Application no: H16-0649-09

Description: Proposed freestanding sign

Amendment: Sign reduced to 5 metres in height (dwg. no. 2)

ACKNOWLEDGEMENT OF AMENDMENT

PROPOSED SIGN

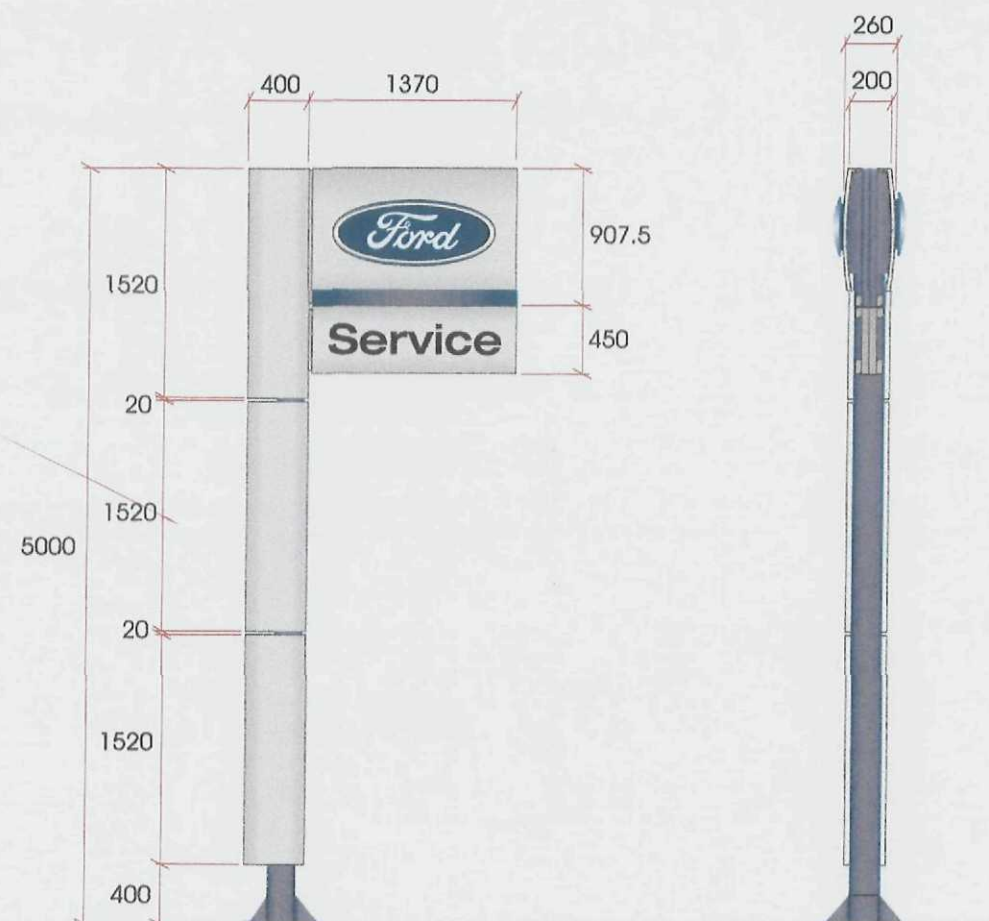
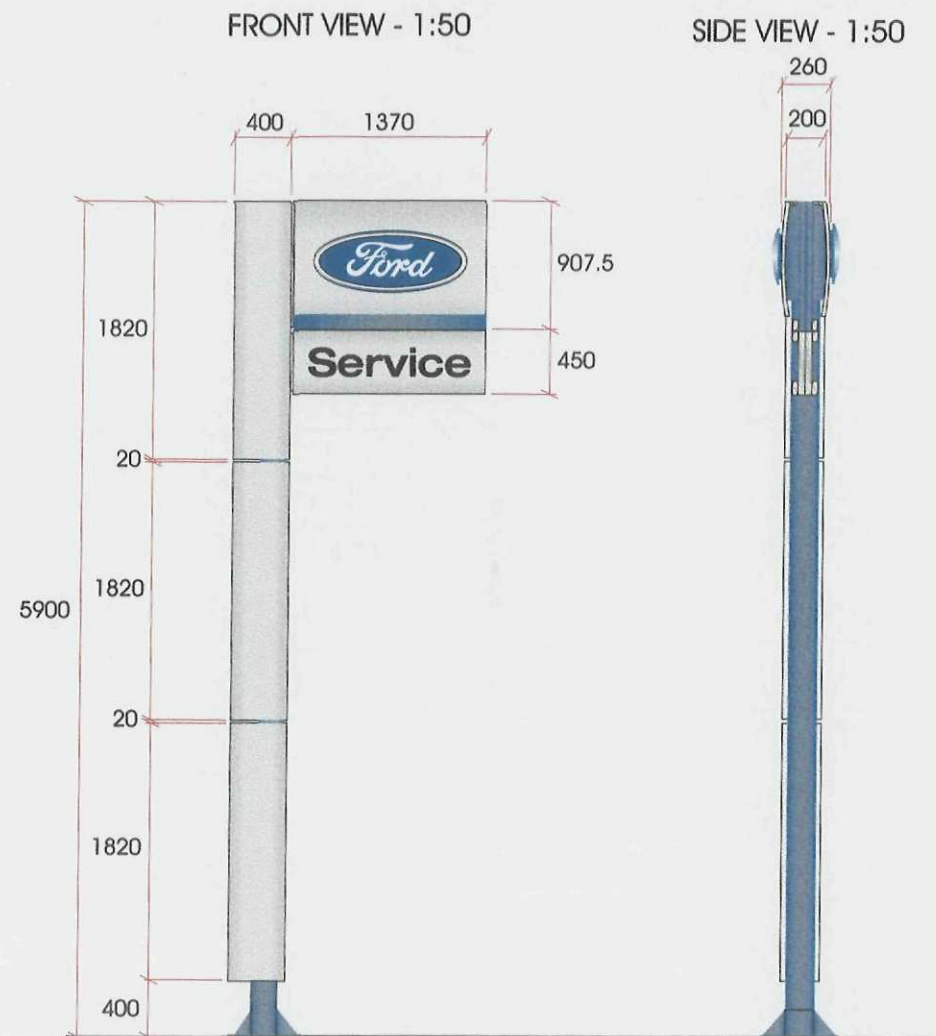
As per our earlier conversation, please find attached our amended proposal showing a 5M Pole sign as requested by yourself.
